OUT20/14674

**Cowal Gold Operations Underground Development (SSD 10367) & Cowal Gold Mine
(DA 14/98) Modification 16
EIS & Modification Report**

Mitchell Isaacs
Chief Knowledge Officer
Water – Knowledge
22 January 2021

Detailed advice to DPIE - Planning & Assessment regarding the Cowal Gold Operations Underground Development (SSD 10367) & Cowal Gold Mine (DA 14/98) Modification 16 EIS & Modification Report

Figure 1 Predicted Annual Bland Creek Palaeochannel Borefield Usage (refer Figure 19 of Appendix G of the EIS)

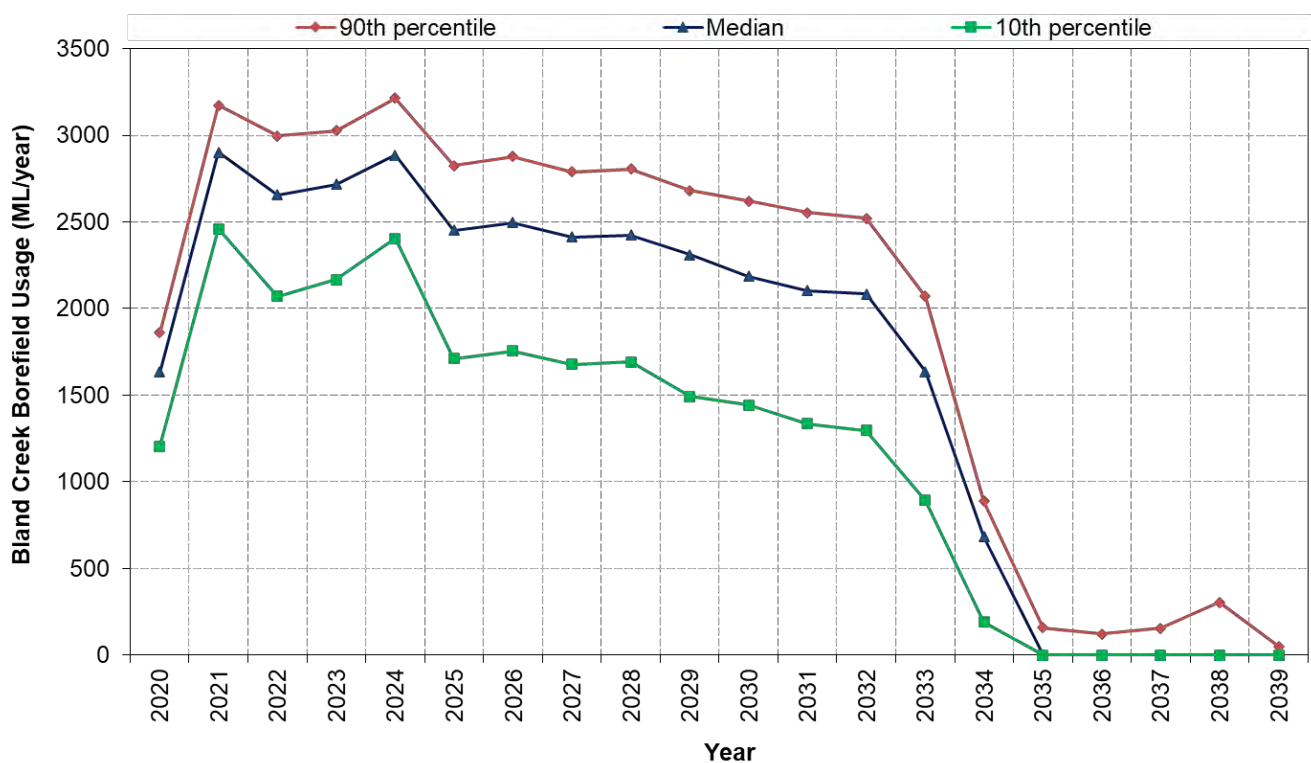
- 90th percentile rainfall sequence (Dry) annual demand from the Bland Creek Paleochannel Bores to be approximately 3,700 ML/year (in year 2022). The proponent currently holds a licence with an entitlement of 3,650 ML/year
- A difference (shortfall) of 109 ML/year between inflow and outflow for the dry rainfall sequence (90th percentile) shown in EIS Appendix G is without any explanation.
- Section 10.4 provides total take from the open pit without separating it by groundwater source (Upper Lachlan Alluvial or Lachlan Fold Belt MDB groundwater source).
- Does not include incidental take from overlying Upper Lachlan alluvium

- Include a strategy for acquiring entitlement shortfall since current demand (90th percentile) from Bland Ck Paleochannel Bores (3,700 ML/year) exceeds current entitlement held (3,650 ML/year).
